Objection to Residential Development with affordable housing 11-19 Middle Harbour road Road Lindfield (SSD-82900461)

Project Name 11-19 Middle Harbour Rd
Project Number 13903
Project Address 11-19 Middle Harbour Rd
Lindfield NSW 2070

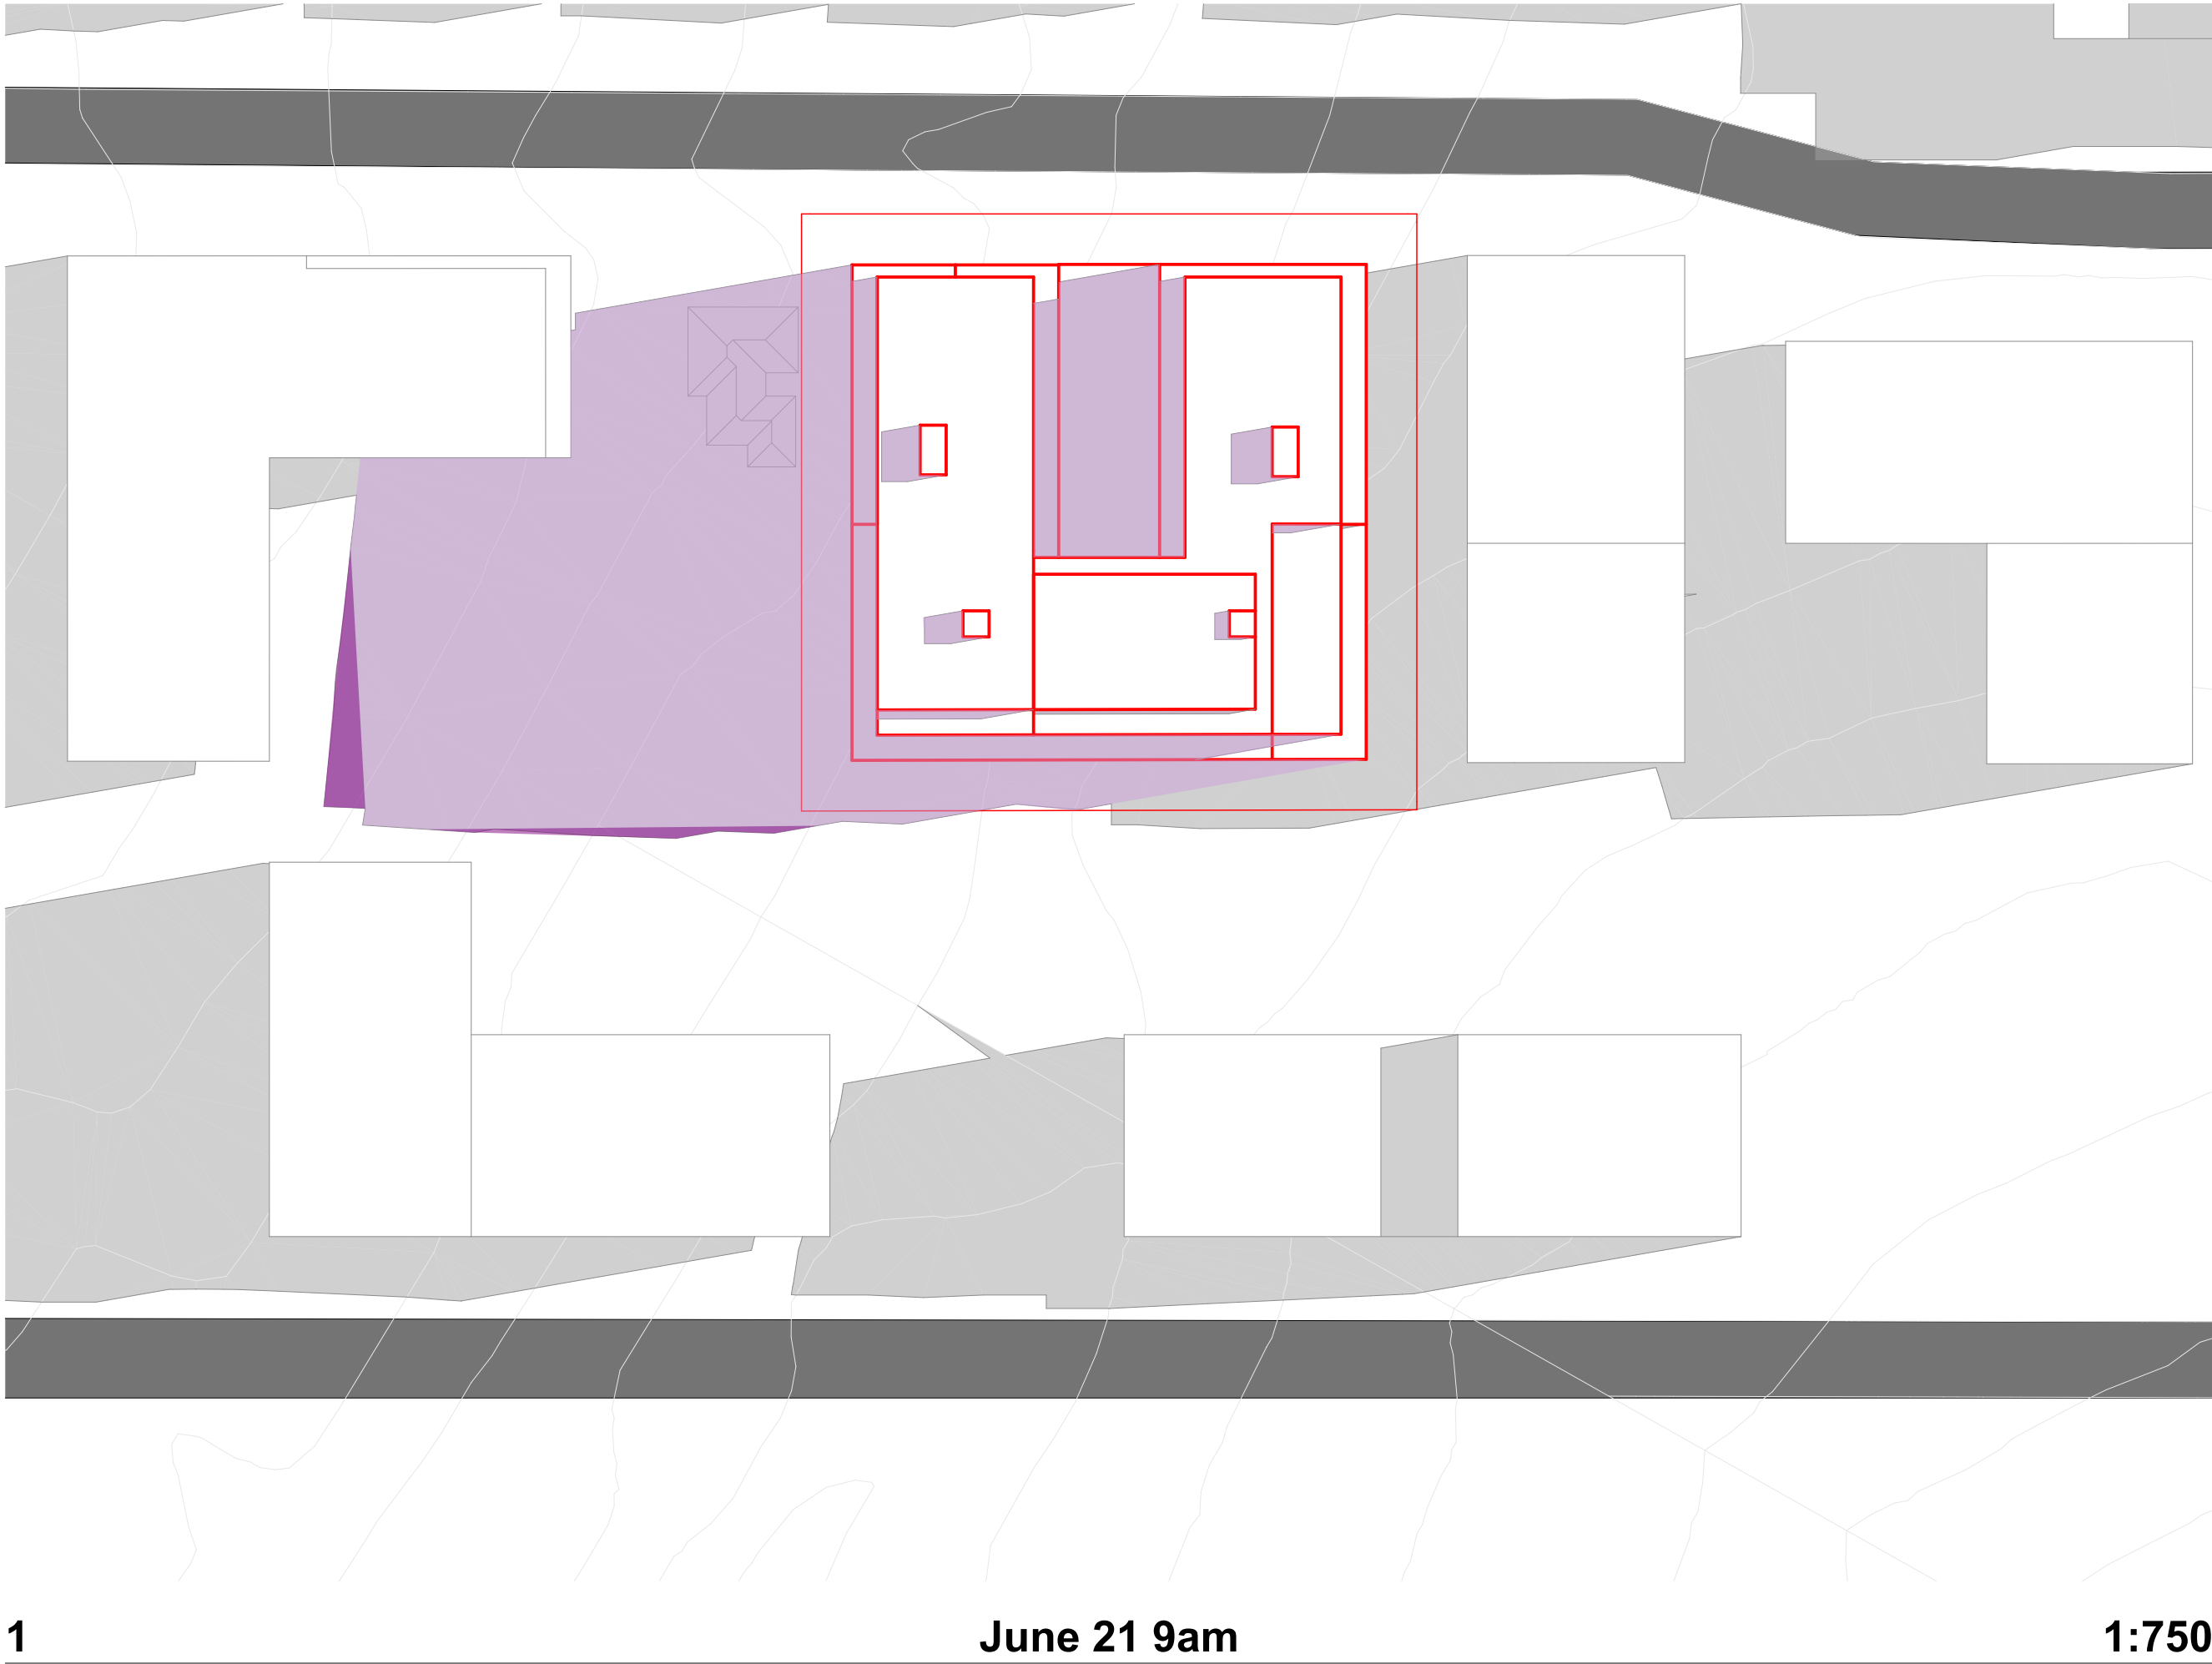
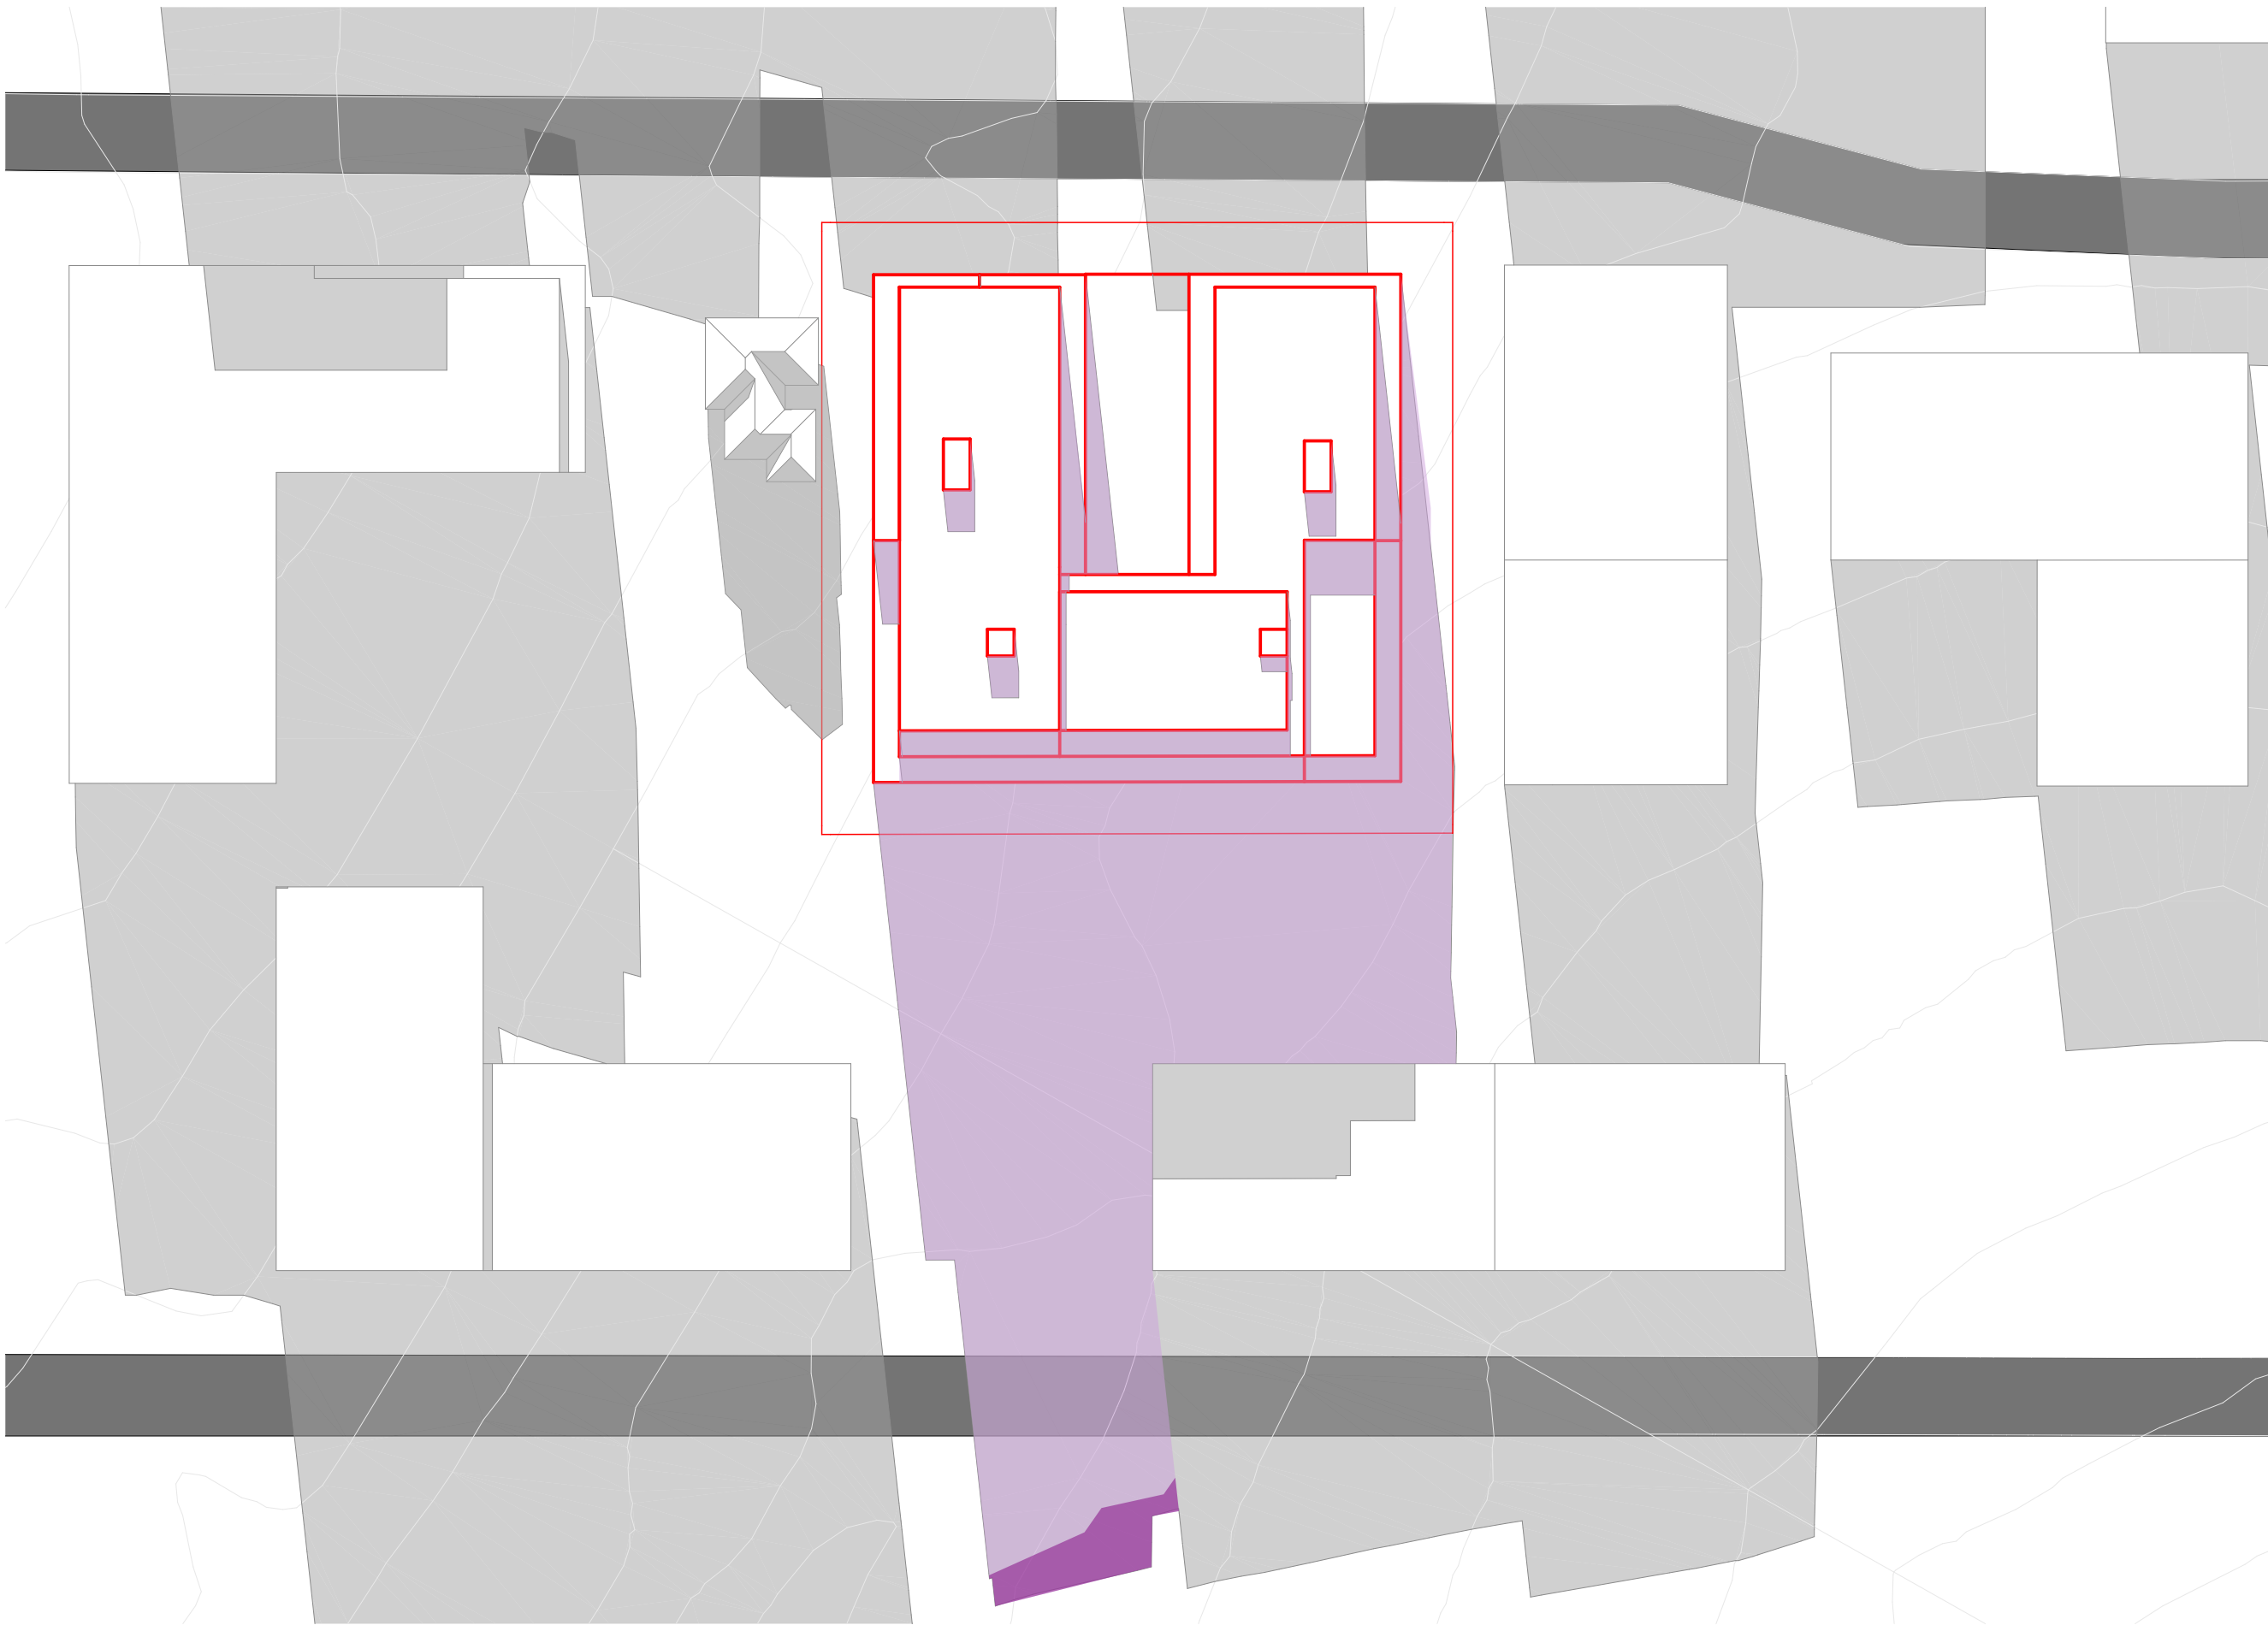
The land which "the Project" is located is higher in the north and lower in the south. Therefore, the setback on the southern boundary of "the Project" should be larger to minimize the shadowing effect on the buildings along Chelmsford Road, which are located at a lower elevation than the Project.

However, the Project does not actually follow the relevant setback rules of KCDP2024. Therefore, “the Project” will cause serious shadowing effect on the direct sunlight of the buildings along Chelmsford Road.
